Re: 2026/91821- Change of use from dwelling (Use Class C3) to residential care home (Use Class C2) at 975 Leeds Road, Deighton, Huddersfield, HD2 1UP

Agnieszka Boryn
Designing Out Crime Officer
Kirklees District

Proposed Ground Floor Plan

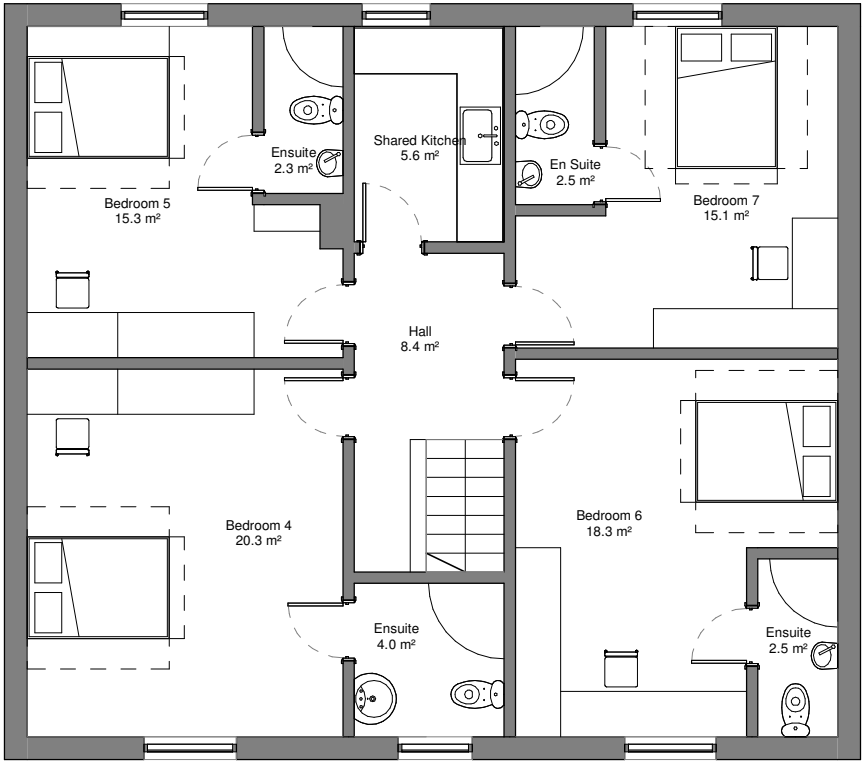
The proposal is to accommodate up to 7 young people, aged 16 and over, in a supported living provision. The application form suggests there will be 2 full-time employees at the provision which appears insufficient compared to the number of proposed residents. The actual staffing numbers have not been provided, apart from the reference to these being proportionate to the number of residents. The DAS mentions shared living and dining areas for residents- I am struggling to locate these on the floor plans, except for shared kitchens which appear relatively small.
